City of Albuquerque Stormwater Construction Site Inspection Report

ESC File No.	C17E119	Project Name:	Horizon Village		
NPDES Id. No.	NMR10023E	Location:	8814 Horizon		
3/10/2021	Owner	Contractor			
Operator	StillBrook	StillBrook			
Contact name & title	Chris Kelsey	Chris Kelsey			
e-mail	ckelsey@stillbrooke.com	ckelsey@stillbrooke.com			
Contact Phone #	858-1500	858-1500			
COA Inspector	Doug Hughes	Start/End Time:	9am		
Construction Phase:	infrastructure nearly complete				
Type of Inspection:	Regular	Storm Event	Post Storm Event >0.25"	311/Complaint	Follow Up
Weather at time of inspection?	Clear	Temperature:	~ 70		
Estimated date of last storm 0.25" or greater	2/22/2021

EROSION AND SEDIMENT CONTROL PLAN

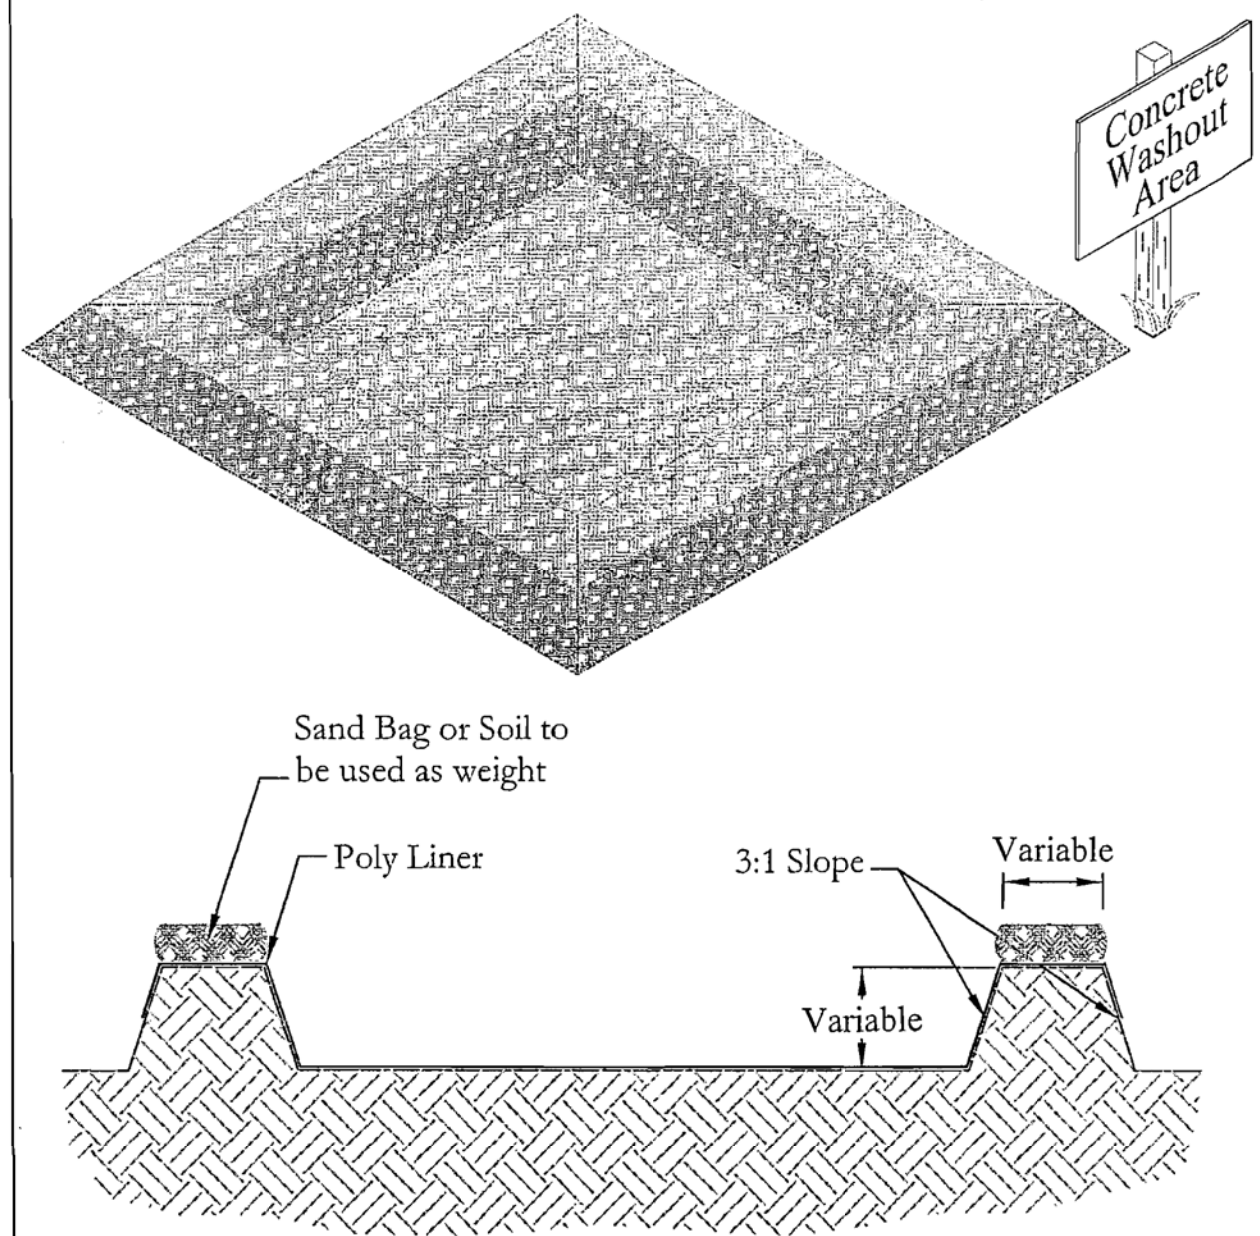
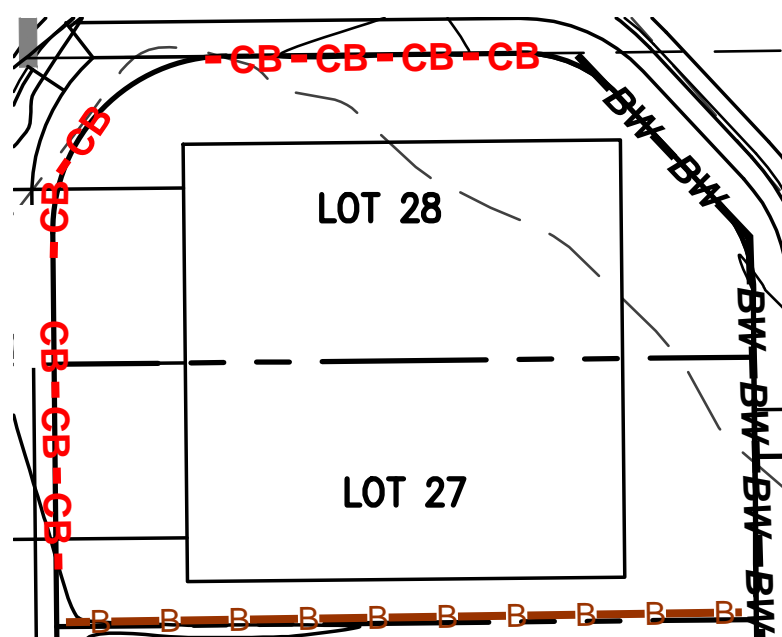
Item Number	Deficiency/ Corrective Action				
1	The NPDES coverage needs posted near the north entrance. The SWPPP location must also be identified on the sign.				
2	Sediment has washed off site into the street west of the site at the two south cul-de sacs. Remove sediment in the adjacent street the same day that it occurs!				
3	Silt fence must be constructed across the two south cul-de-sacs. Be sure that it is properly embedded and it does not have any holes.				
4	Disturbance has occurred about 15' east of the site and needs to be stabilized per CGP2.2.14. Please provide an updated ESC Plan showing the disturbed area, a schedule, and specific stabilization (landscape plan) for common areas and offsite disturbance.				
5	***Please provide the latest SWPPP self-inspection report.

Notes:	
Stabilization per 2.2.14 is needed on all areas at grade.	
Seed and mulch should happen soon to correspond with the growing season.	
Rock mulch is recommended if Irrigation is not available.	
Keep sediment out of adjacent street and parking lot.
